From: Gilbert LaForce
Sent: Thursday, January 21, 2021 3:13 PM
To: 'David Mijares'
Cc: Elizabeth Nijkamp; Nina Ruiz
Subject: RE: Riverbend Preliminary Plan

From: Gilbert LaForce <GilbertLaForce@elpasoco.com>
Sent: Tuesday, January 12, 2021 5:47 PM
To: David Mijares (david@catamounteng.com) <david@catamounteng.com>
Cc: Elizabeth Nijkamp <ElizabethNijkamp@elpasoco.com>
Subject: Riverbend Preliminary Plan

S-1

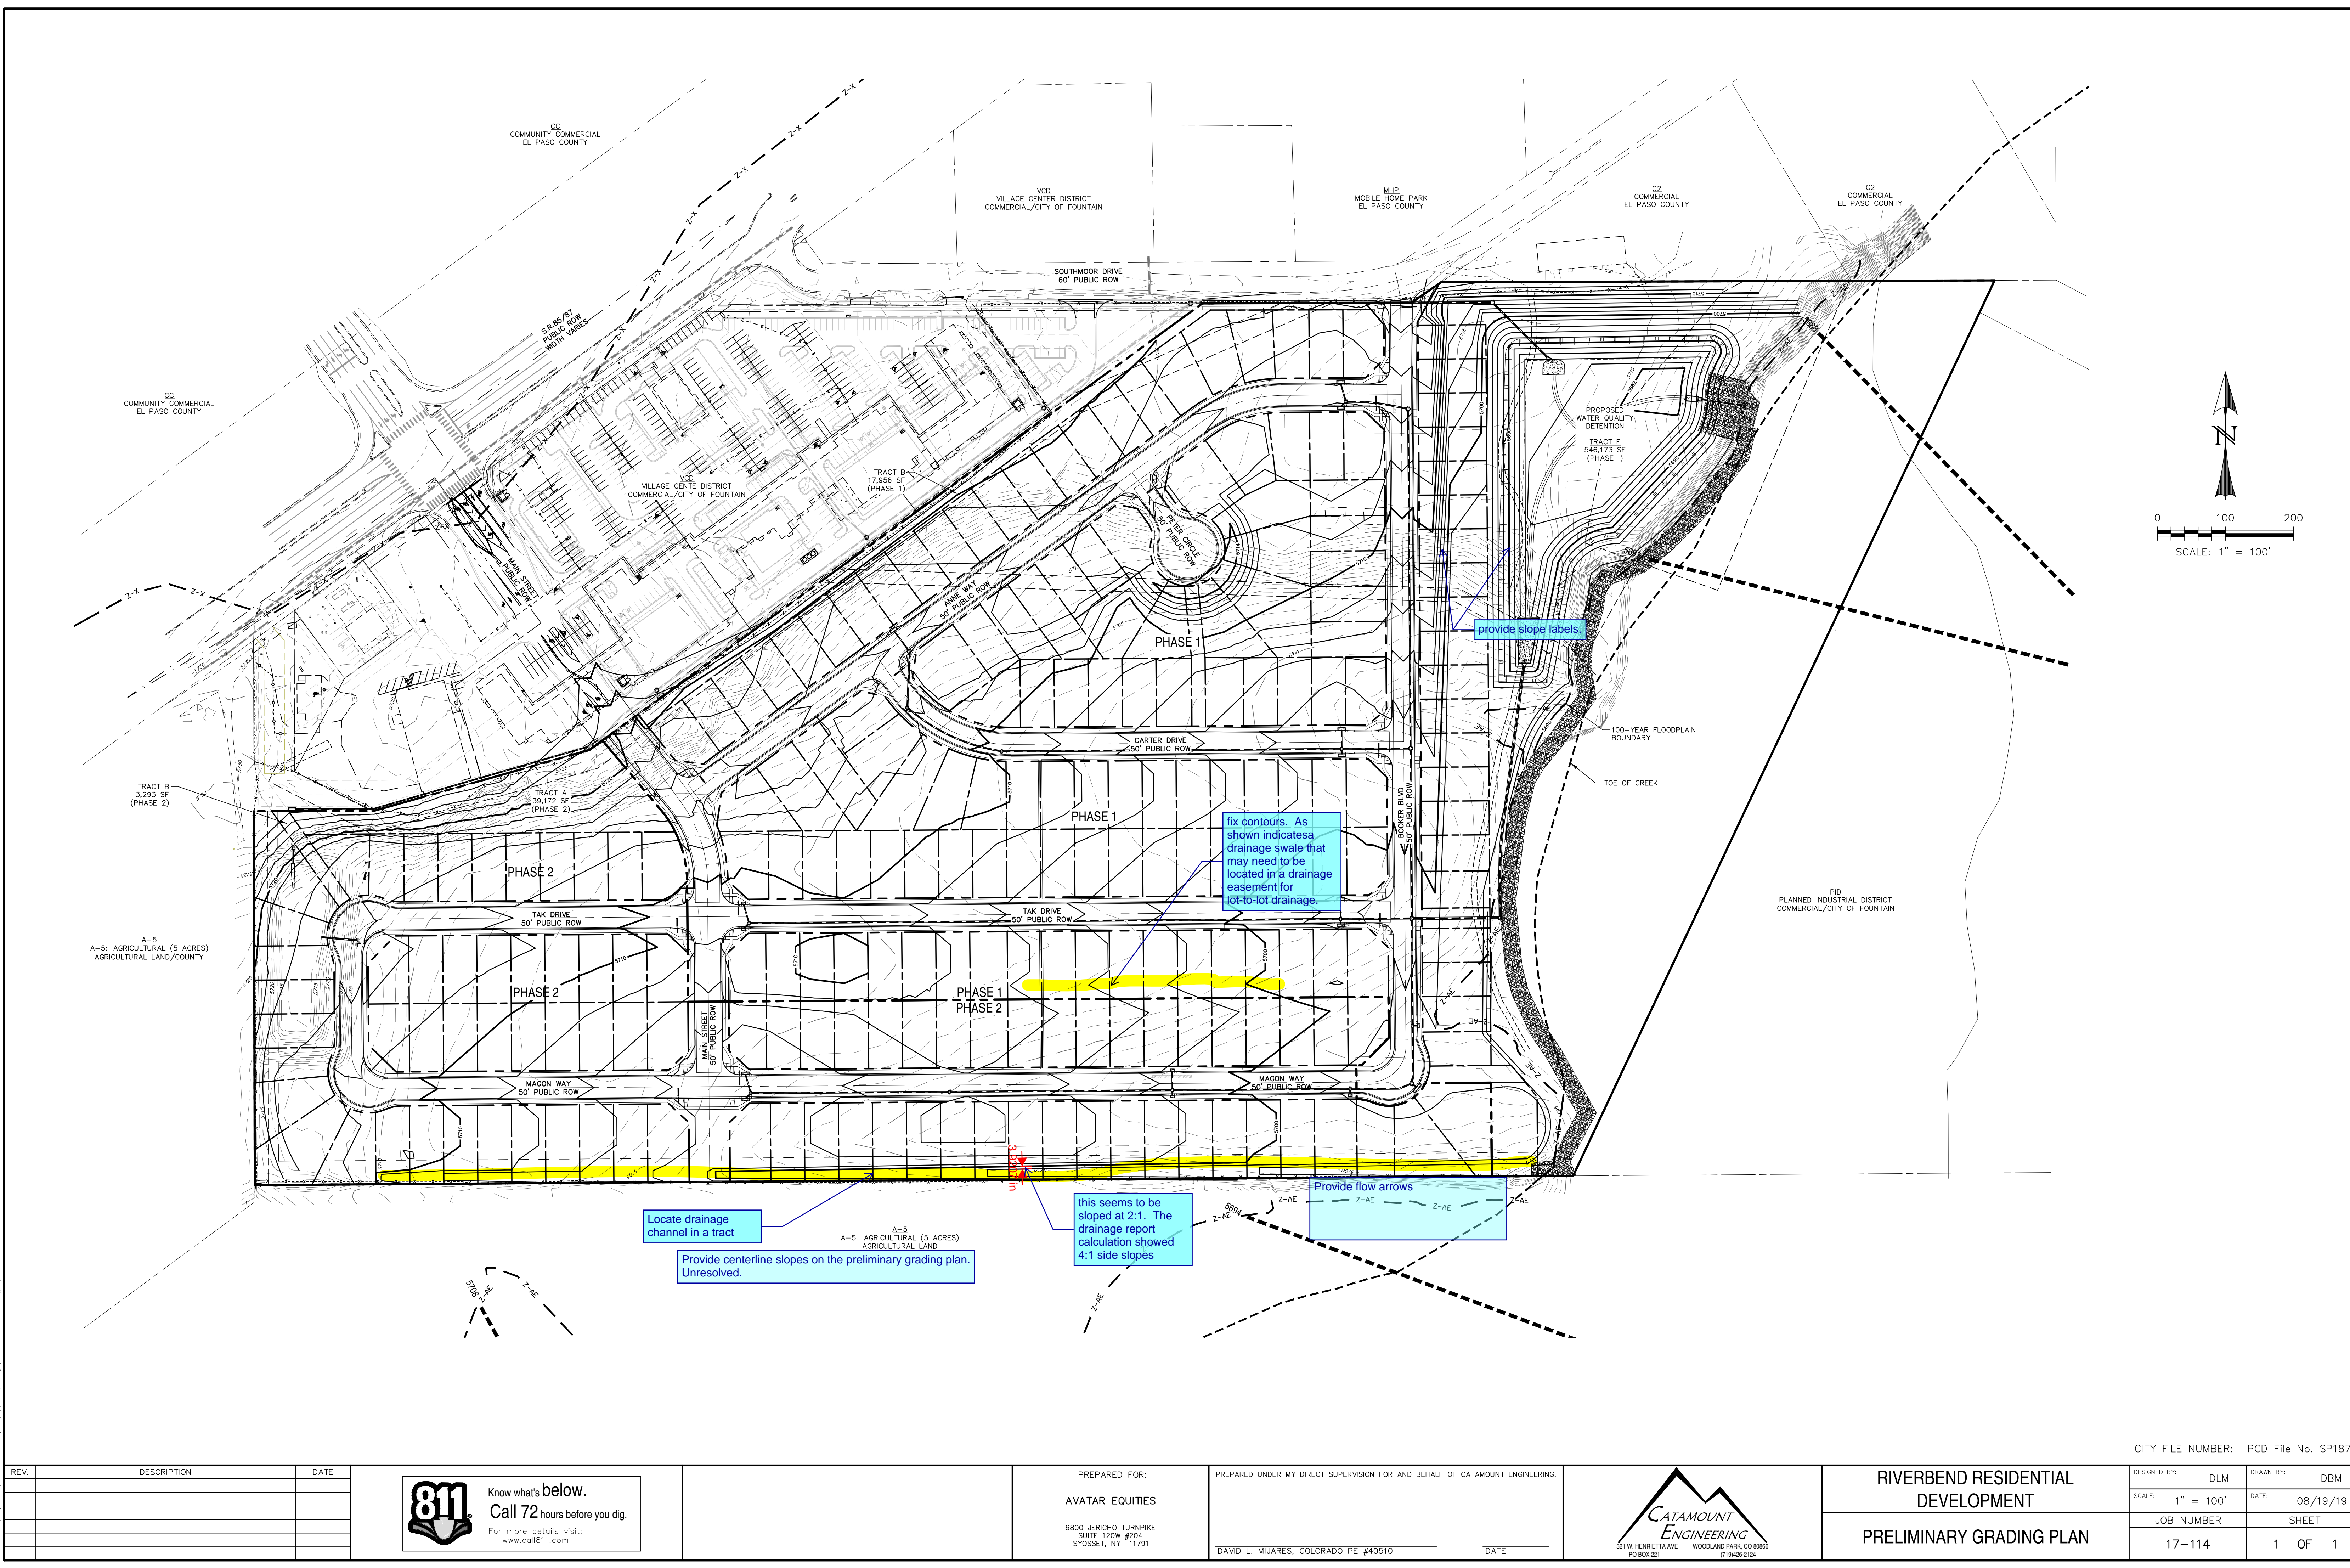
My unresolved comment has to do with Southmoor drive widening. The end goal is to provide information on how the travel lane fits into these cross section.
Identify travel lane, shoulder and median widths. For the no curb section where the median tapers to zero, then identify "varies (0'-12')".
Typical non-residential collector includes a 6' paved shoulders but the cross section does not identify any and I can't tell if there is room since the cross section does not define how wide the asphalt mat section will be after the street widening.

Discussed this with Elizabeth and we are agreeable to the cross section. She will require a deviation request especially since the western half does not have the 6' shoulder. She'll also discuss the situation with Jennifer later today.
